From: Sarah Burrow <Sarah.Burrow@arun.gov.uk>
Sent: 19 May 2022 10:41
To: Planning.Responses <Planning.Responses@arun.gov.uk>
Cc: Maria Tomalova <Maria.Tomalova@arun.gov.uk>
Subject: RE: Planning Consultation on: BN/26/22/PL

Engineers Comments Regarding Surface Water Drainage

Application No: BN/26/22/PL
Registered: 28th March 2022
Site Address: Land East of Eastmere House Eastergate Lane Eastergate PO20 3SJ
Grid Reference: 495273 106065
Description of Works: Construction of 1 No. two storey detached dwelling house on existing paddock. This application is a Departure from the Development Plan and is in CIL Zone 3 and is CIL Liable as new dwelling.

JOB No.	STATUS	DRAWING No.	REV
C2027	PL	100	PL-

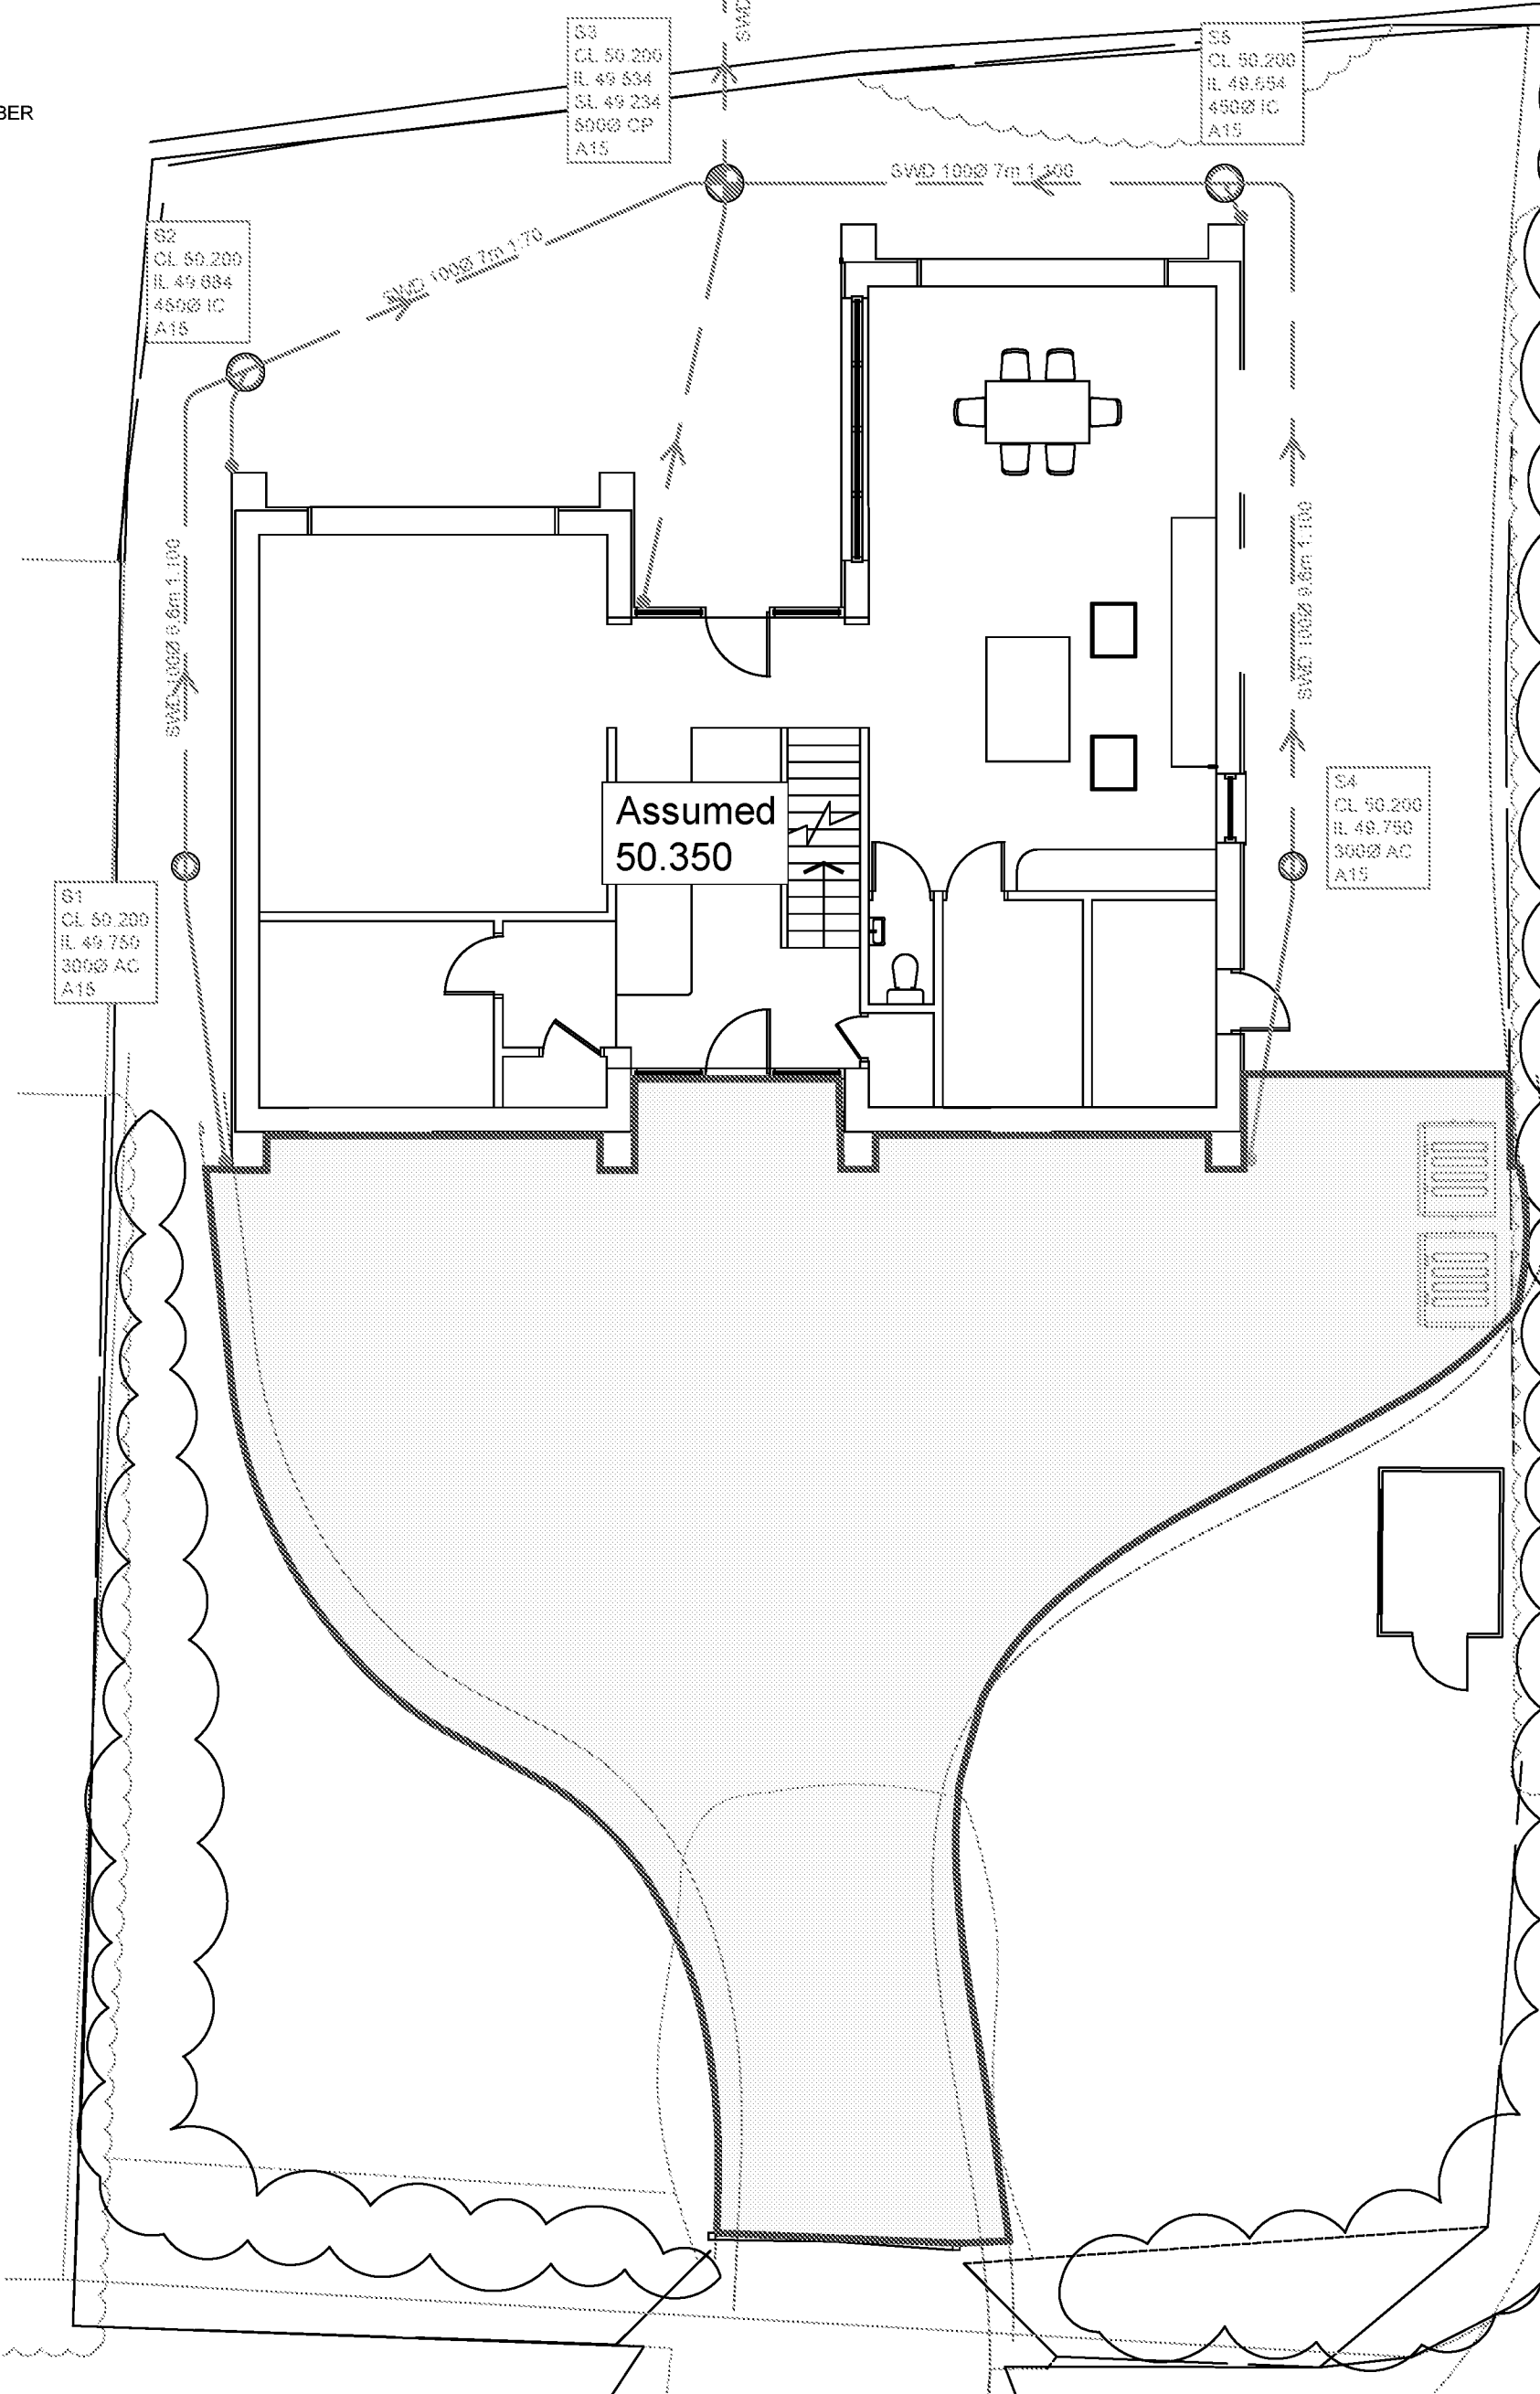
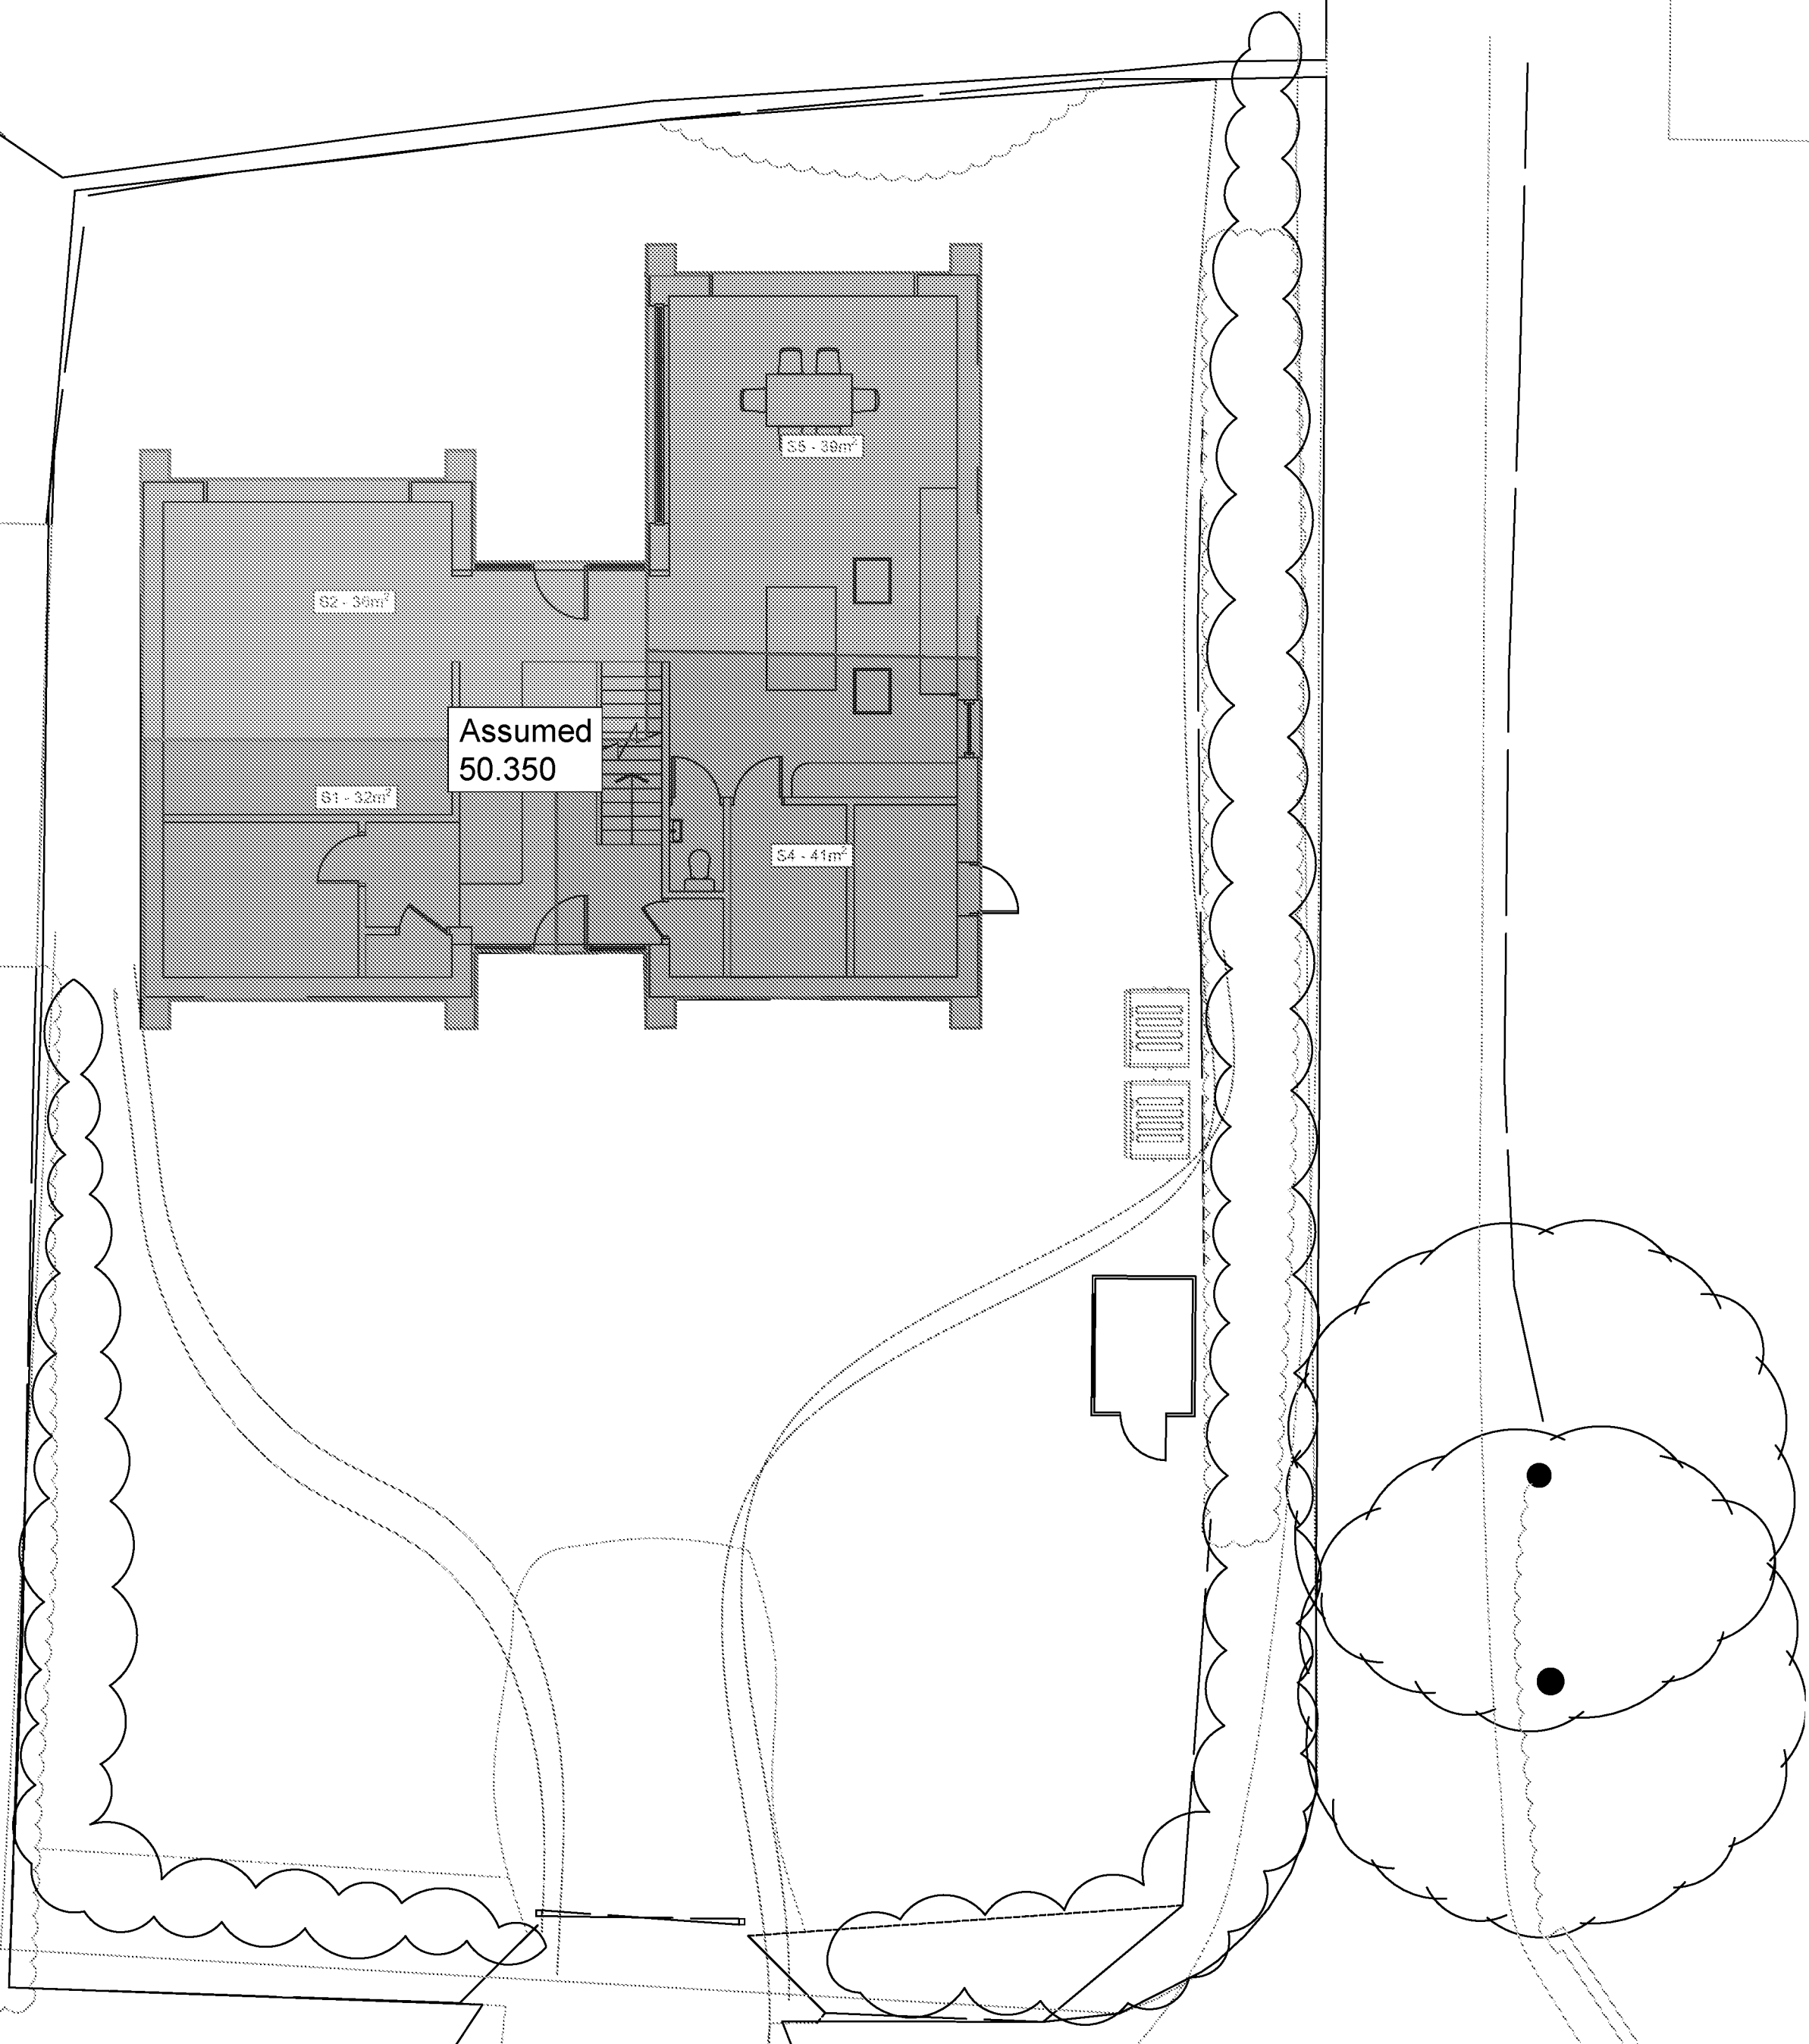
4. S2 and S5 are located after bends in the pipe at the corners of the proposed building, please relocate these so that the bends are removed.
5. Please include the invert level of the entry pipe to the soakaway, this must be located above the 1 in 10 year +40% water level. Please also include calculations for this event.
6. Infiltration rate should be supplied to base or sides of the soakaway not both, particularly given that the groundwater monitoring period was short – thus increasing risk.
7. Please include a construction detail of the vents for the soakaway with the drawings.
8. CV of 0.75 is used for all events, we would normally see CV of 0.75 for summer and 0.84 for winter although CV of 1 is best practise. It also appears that only summer storms have been modelled which may explain the error. Please include winter storms with the appropriate CV value.
